**SYDNEY OLYMPIC PARK AUTHORITY
DESIGN REVIEW PANEL
ADVICE SHEET**

Project	Site 4 B
Presentation / Review Date	9 November 2006
Panel Present	Peter Mould James Weirick Darlene van der Breggen Helen Lochhead
COI Declaration	nil
Also Present	
Presenters	Phillip Vivian (Bates Smart) Fleur Mellor(BLL) Paul Mottek
Documents made available	A3 report of analysis, principles and sketch plans, photomontages
Inherited decisions	Nil
Previous relevant SOPA Advice	DRP Advice August 2006
General Observations/ Overall Comment	The proposal is for a 7-storey L-shaped commercial office building. The proponents have developed the design in response to the DRPs request. The key changes to the design include: • The treatment of the lift core. The size of the core has been reduced by relocating 2 lifts into the atrium space and deleting toilets from the ground level to increase visual permeability into the lobby. • The relocation of the fire stairs within the body of the building • Extensive use of glazing and more open plan areas in the atrium to improve transparency into the building • The use of wintergardens on the Herb Elliot and Boulevard elevation to enliven the building expression • The increase

Elevation East

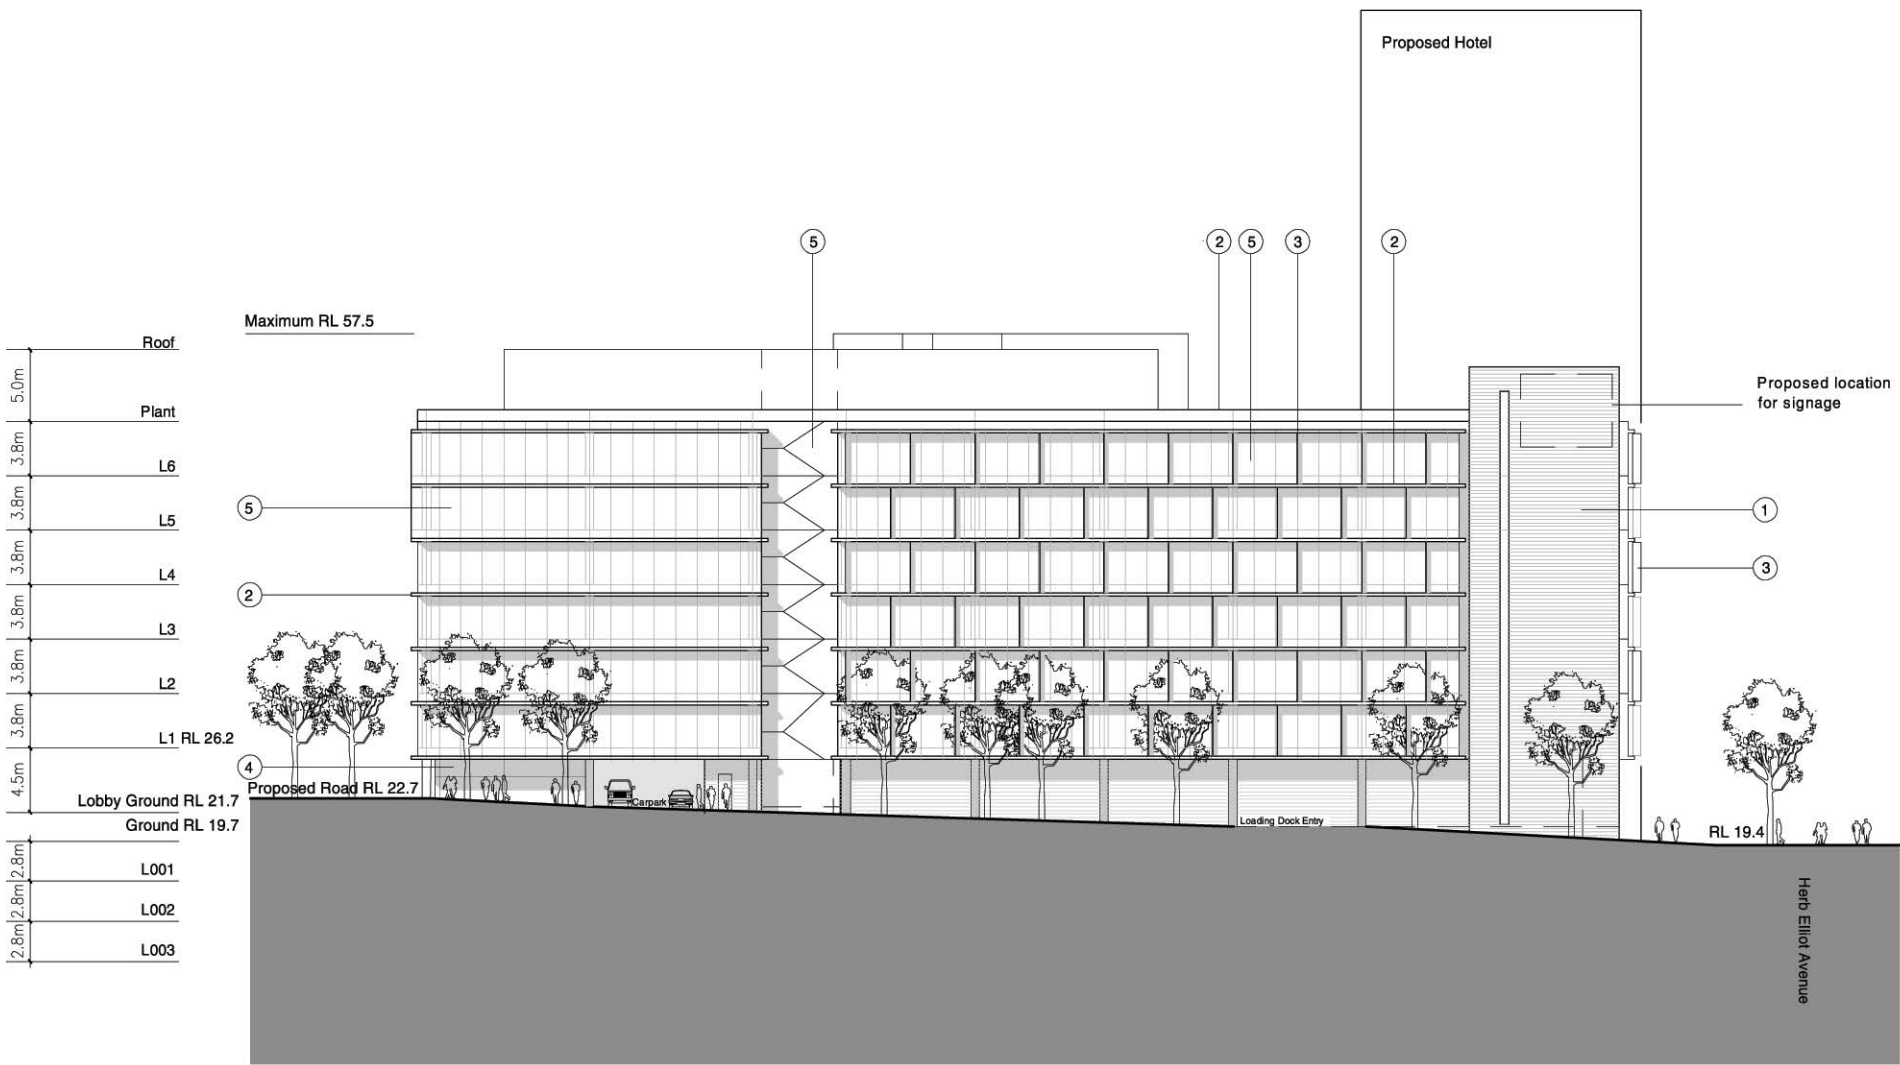
soffit height of the colonnade at Herb Elliot could be possibly maintained to facilitate this connection • The street address on Olympic Boulevard needs to be commensurate with the civic role of the Boulevard and be further developed with elevational studies in relation to the Novotel and Sofitel to test the presence of the new office building in the emerging street scape • The colour palette of the glass and terracotta elements be developed in a considered relationship with the Sofitel and CBA buildings on Herb Elliot Avenue • The landscape treatment should read as a continuation of the public domain, not a private courtyard of the new development. The landscape integration has still to be presented in any detailed way. This needs to be addressed as a matter of priority • The landscape proposals presented are preliminary but seem to concentrate on the planting beds and trees. There seems to be little consideration as a through site link. This may be addressed with the potential remodelling of the ground floor foyer mentioned above and the relationship of the foyer to the adjacent public realm. • There needs to be a methodology for the protection of the remaining trees through construction. • The address to the future side street. The size and treatment of the loading dock and garage entry need to be given more design consideration. At present this is a back entry but in the future this side of the building will have frontage to this new street and should be treated as such.

OLYMPIC BOULEVARD ELEVATION

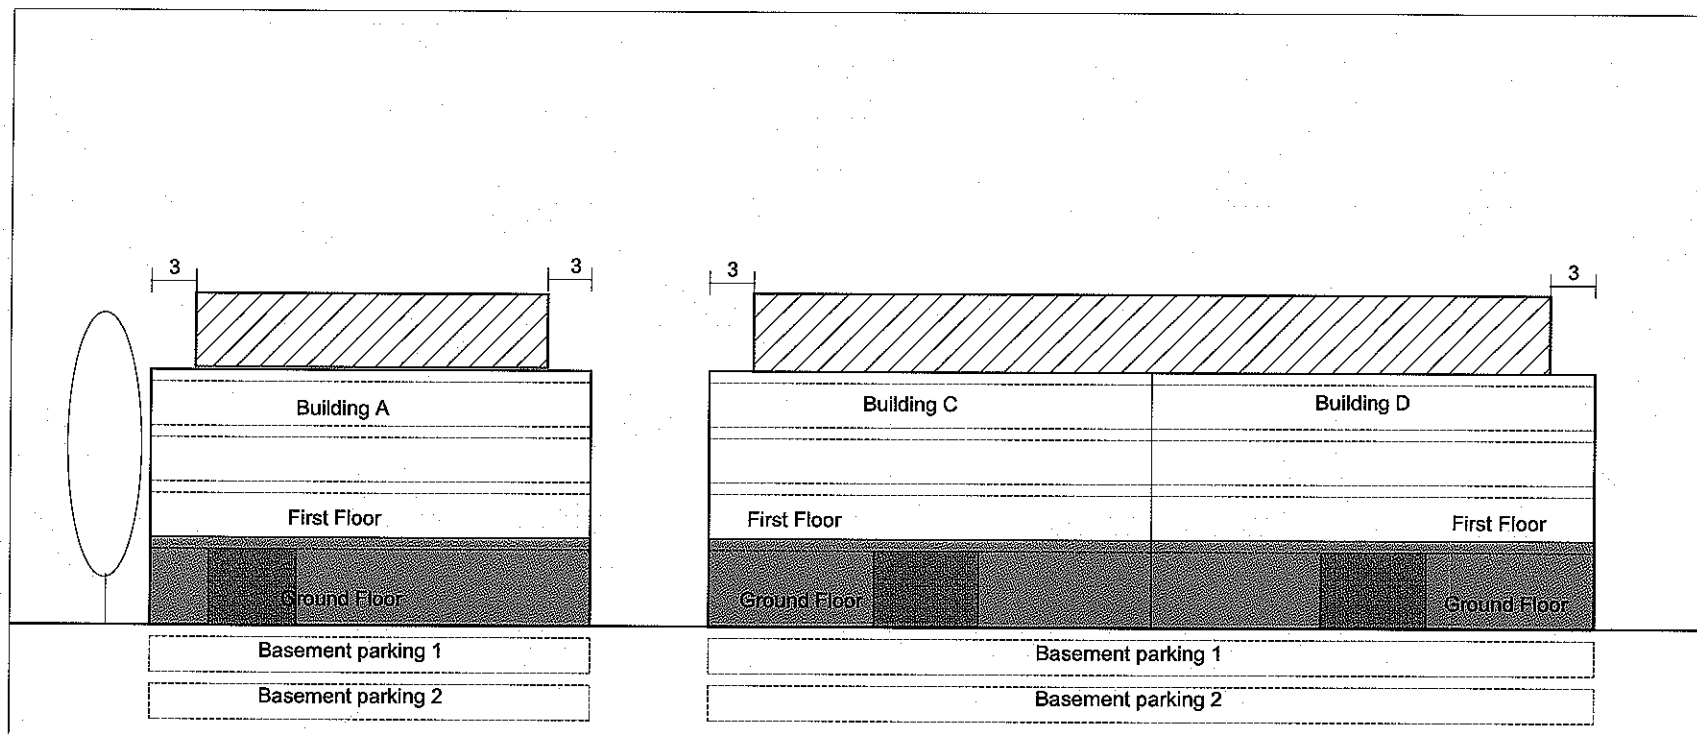
Matters for consideration	The Panel recommends that the proponents address the above issues
Recommended Supporting Action	The proponents should work with SOPA to resolve the above issues and present to the next DRP. Future submissions should also include the view from Olympic Boulevard, as originally presented
Circulation of Advice	SOPA, proponents
